**RE: Request for Information 2 for File No. SUB16-011
7239 LLC 2-lot Short Plat
7239 SE 27th St / Mercer Island WA 98040; King County Tax Parcel #: 5315100695**

Robin,
Thank you for your request for information dated April 2nd, 2018. Below I have reproduced your comments and questions and have included my responses in red. If you have any questions, please don't hesitate to call me at 425.486.1252 x2 or email me at mark@meadgilman.com.

Drawing file: SUB5 / 16082 sp-sheet 3 updated on 02062019.pdf

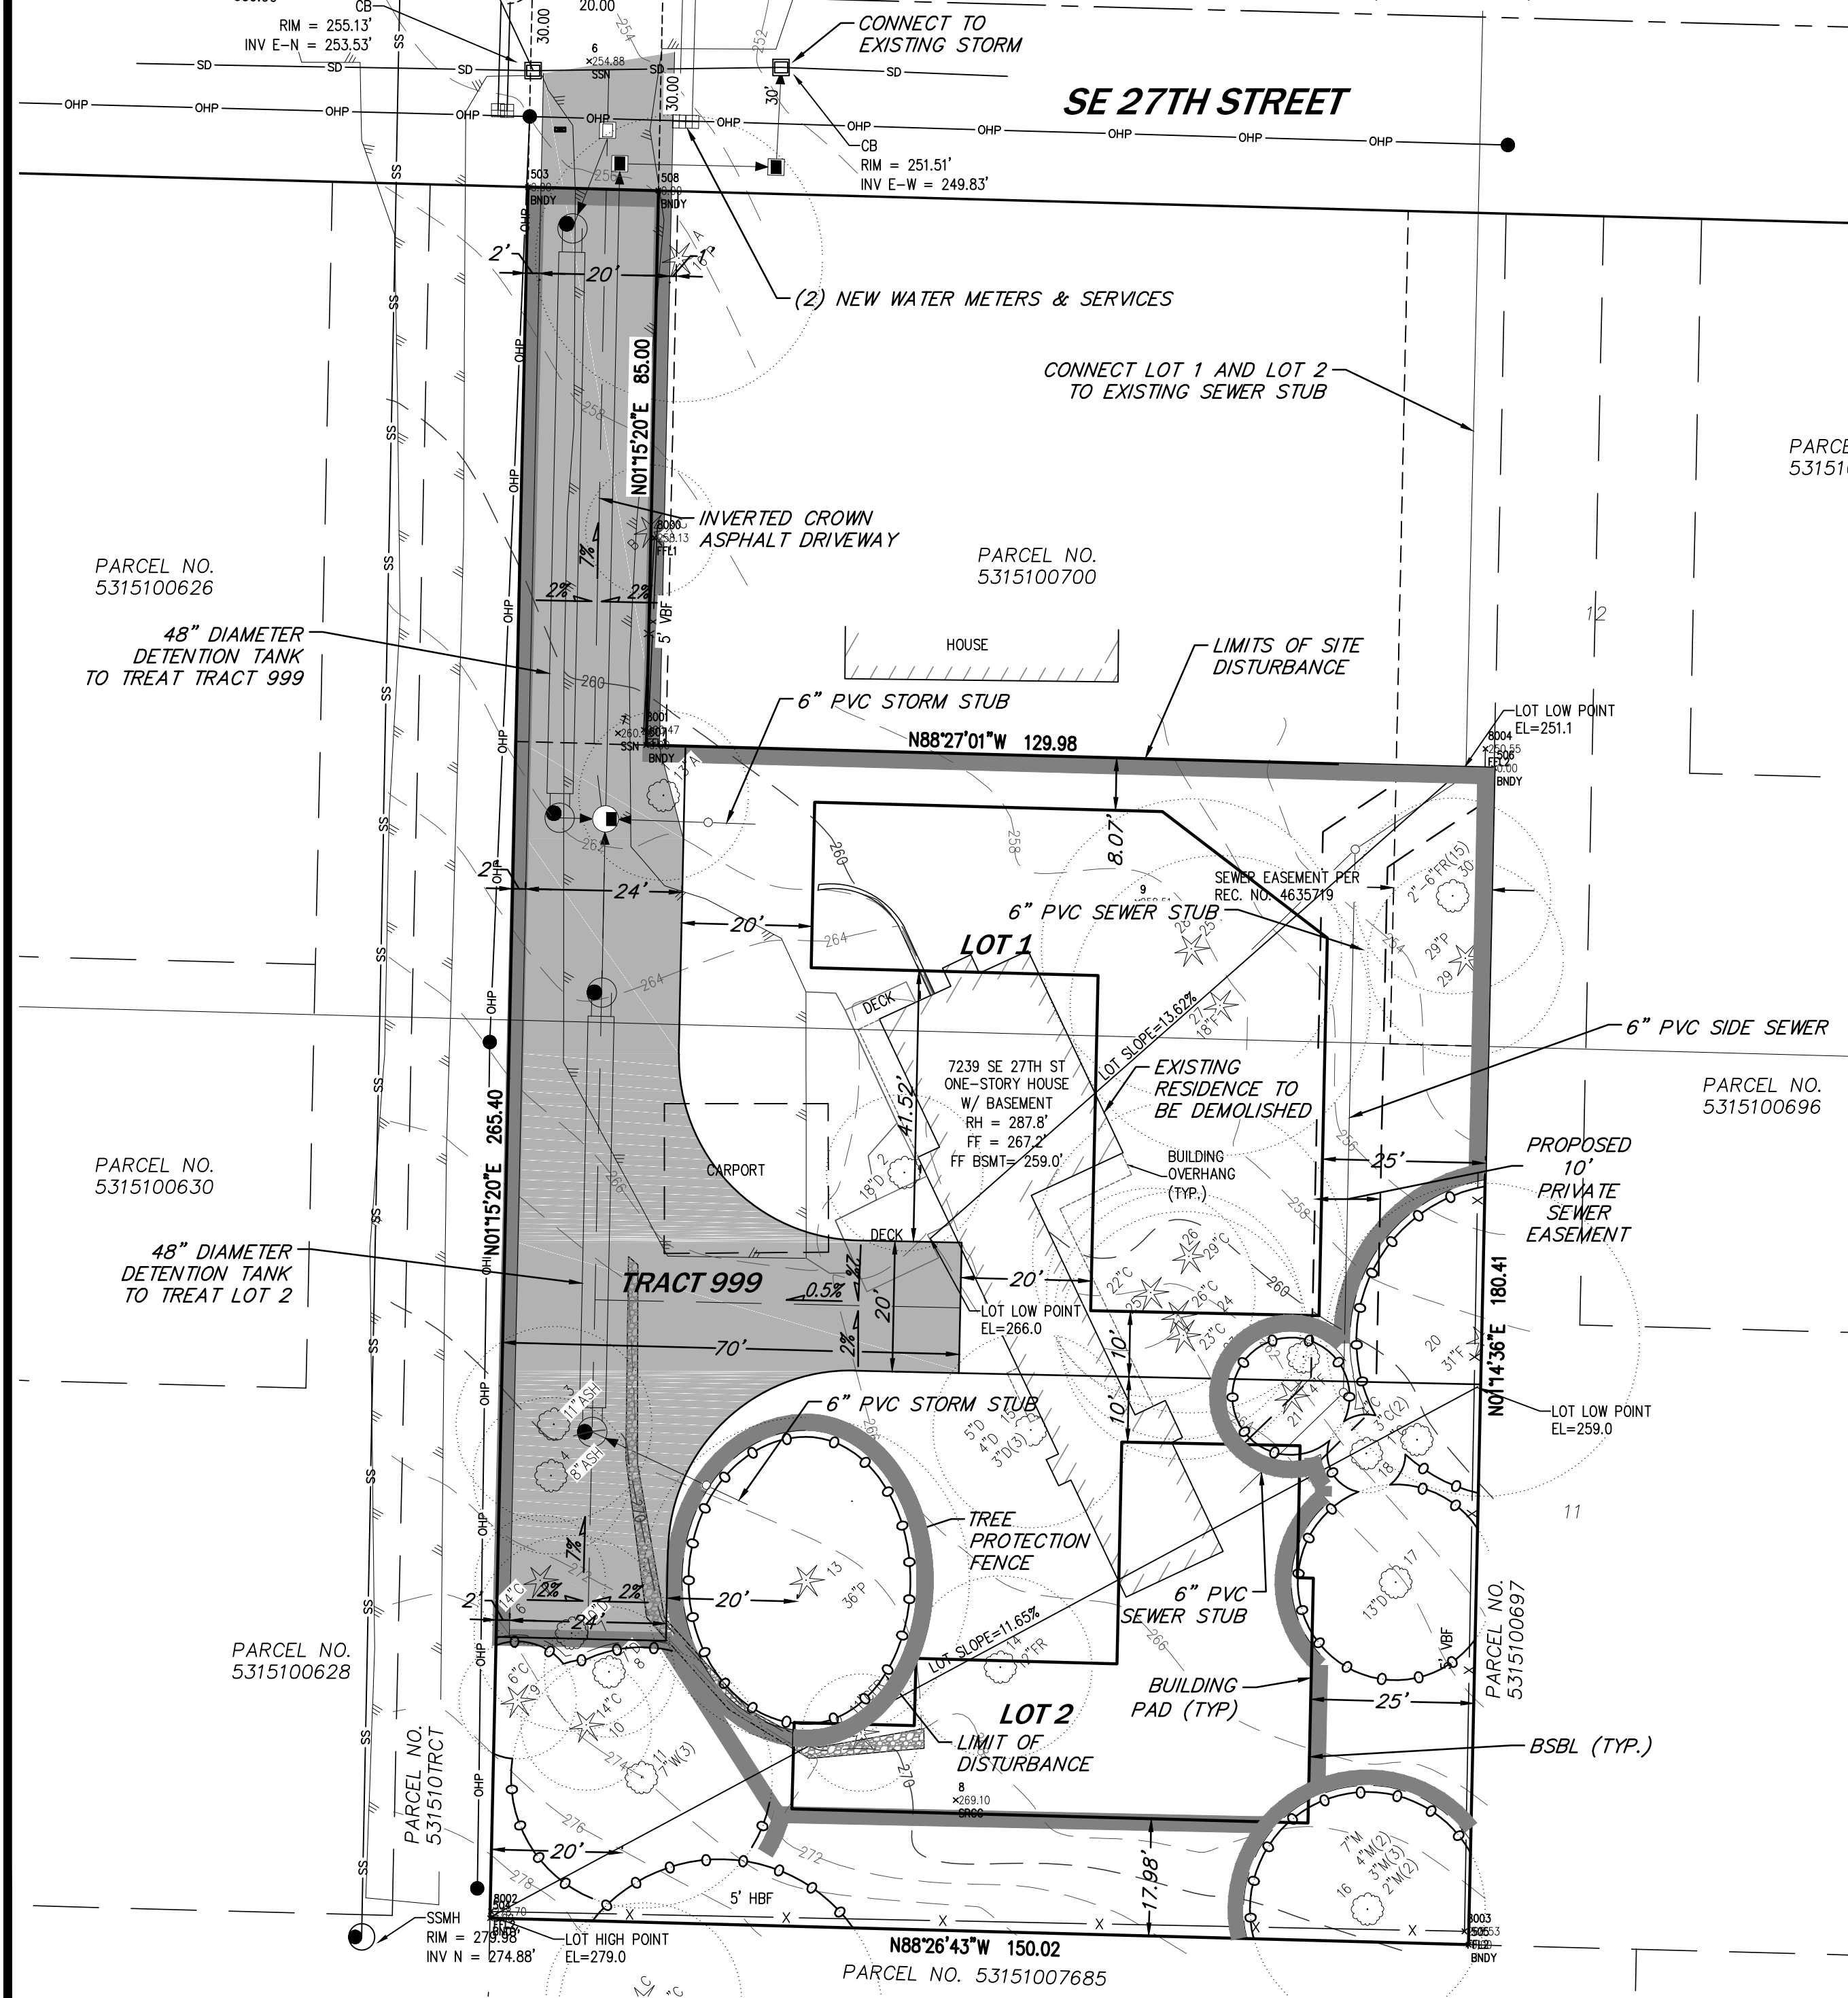
2. Revise the building pad for Lot 2 to be outside of the area of protection for Tree #13, and allow sufficient room for excavation. Please provide a plan sheet showing 1) tree protection fencing, 2) extent of excavation, and 3) revised building pads.

The building pad is now shown, sheet 3 has been updated to reflect the revised building pads.

P.O. BOX 289, WOODINVILLE, WA 98072
 425.486.1252 (TEL) 425.486.6108 (FAX)
 PROJ. NO. 17032 SHEET 2 OF 3

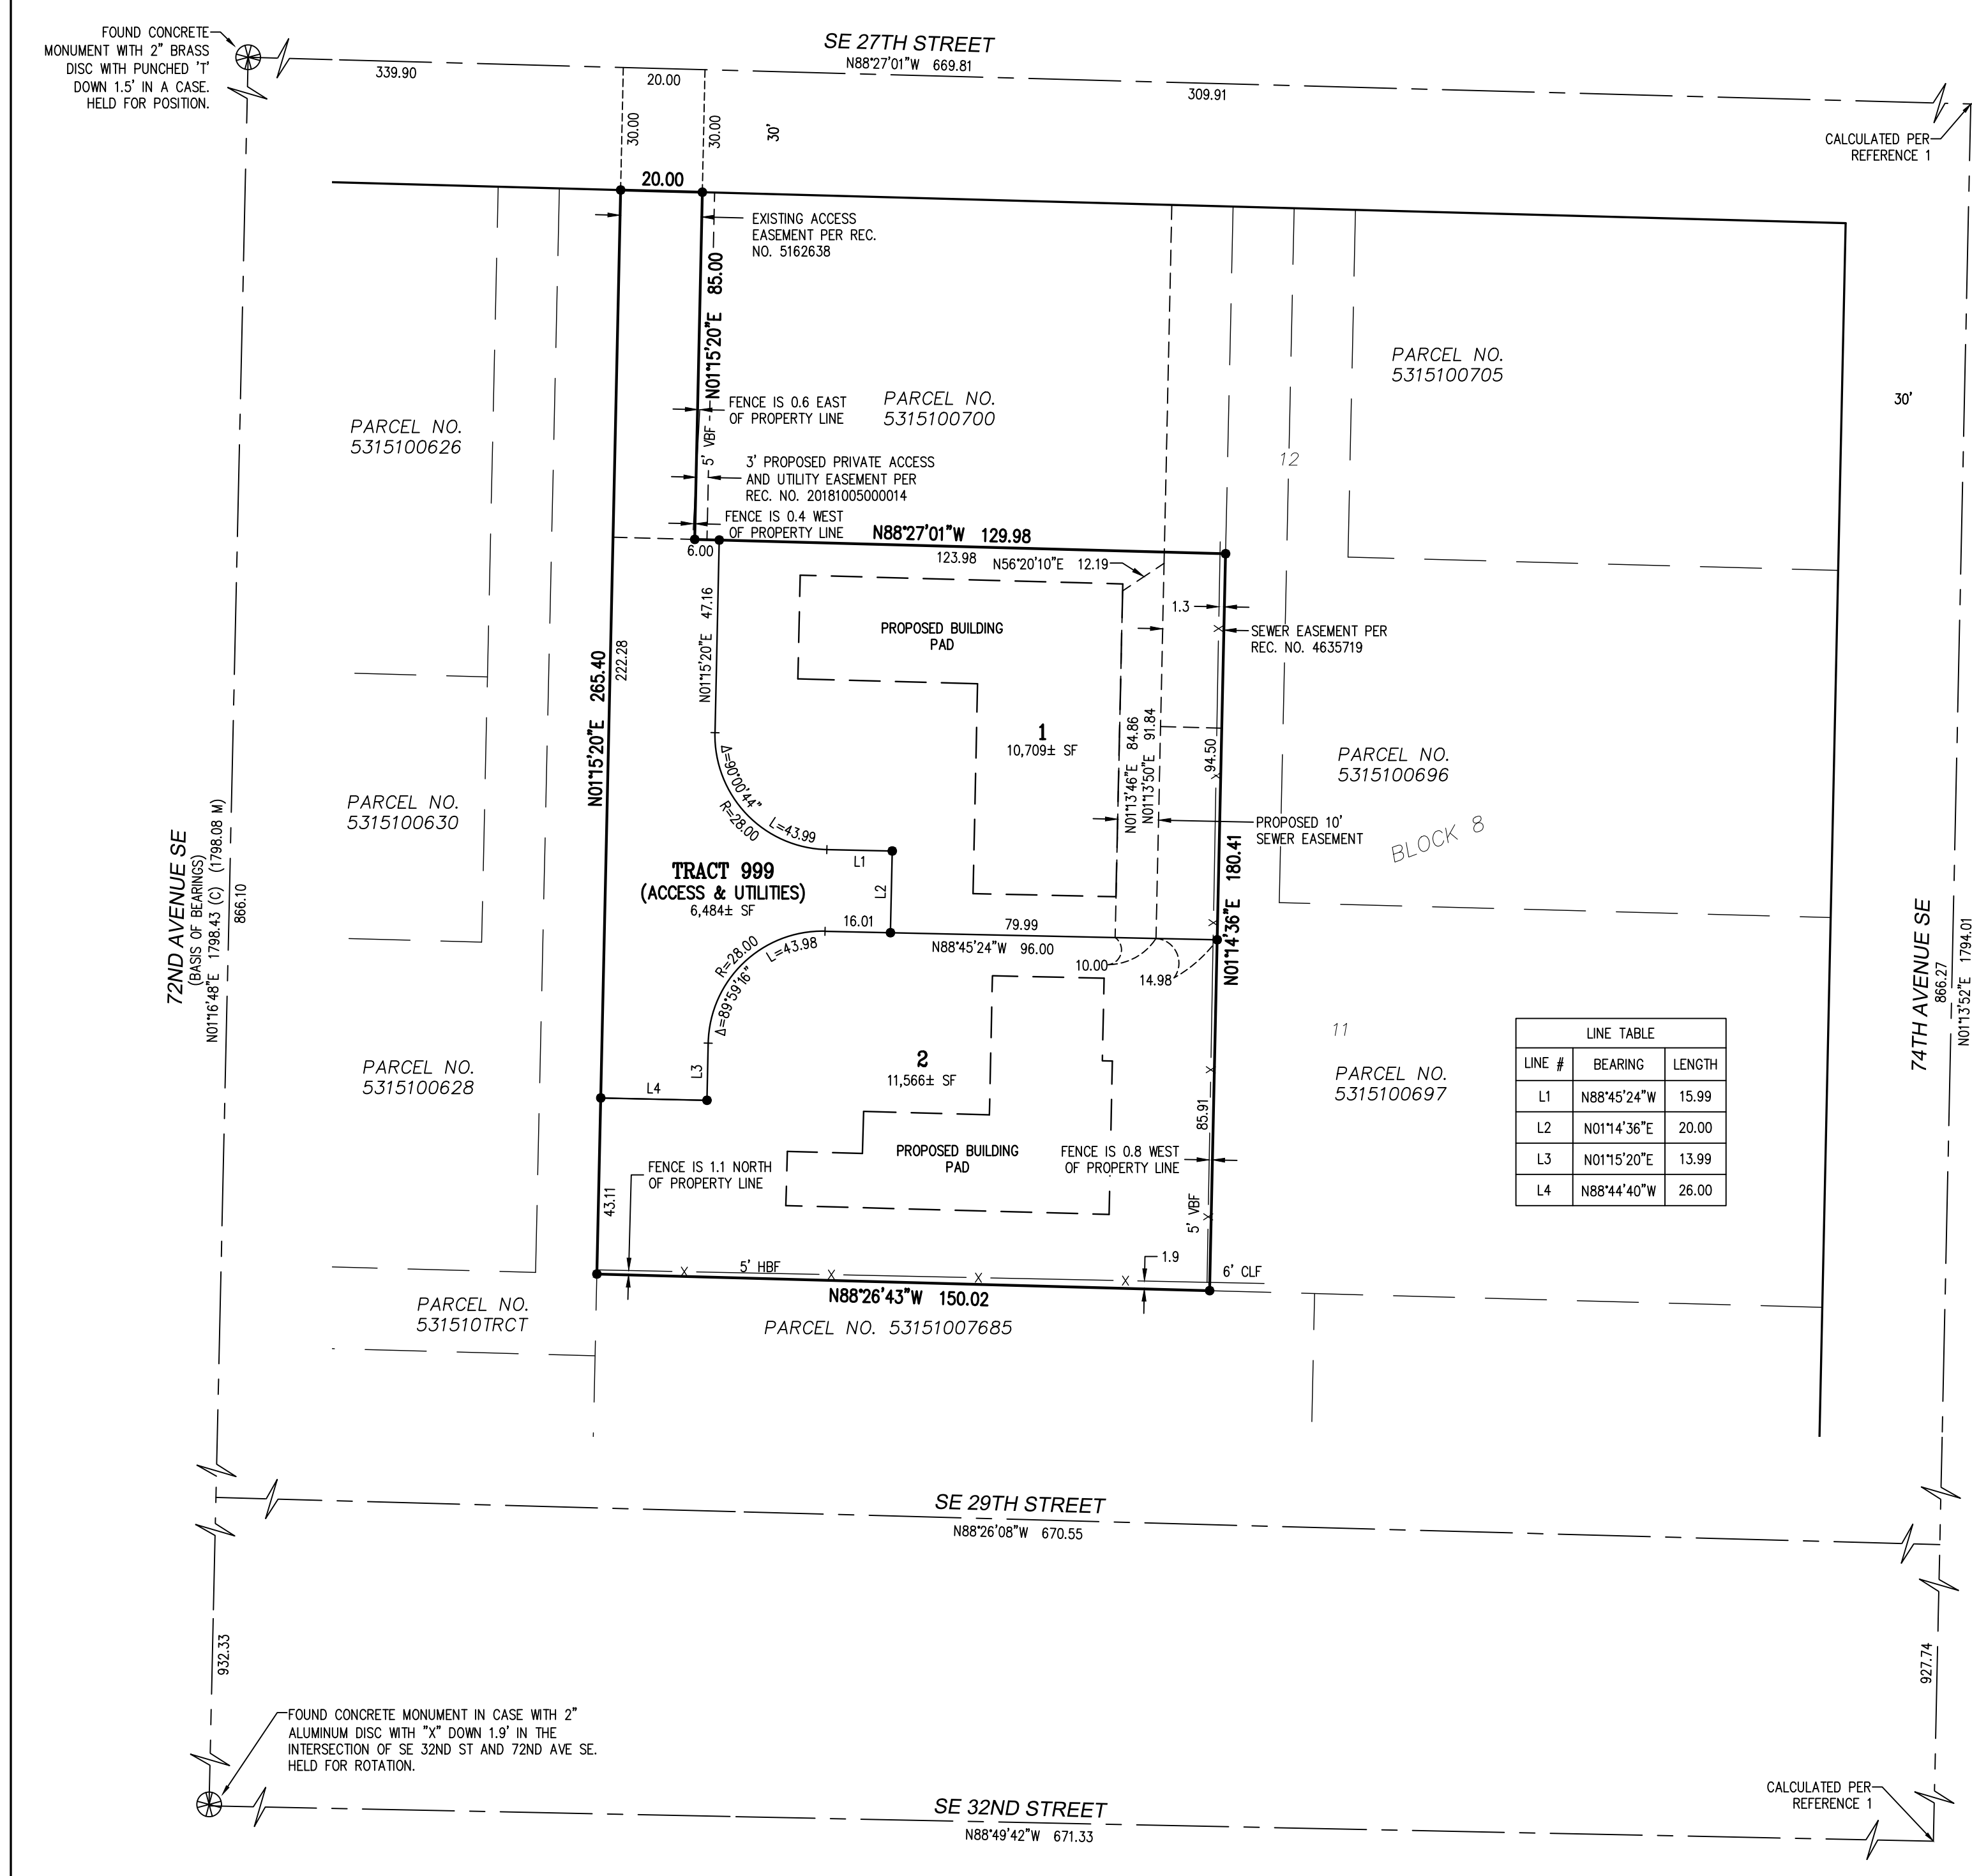
1. Please revise Sheet 2 of the preliminary plat to show building pads, instead of boundary setback lines, on the proposed lots.

Sheet 2 of the short plat has been revised to show the building pads. Building setback lines were removed from this sheet.
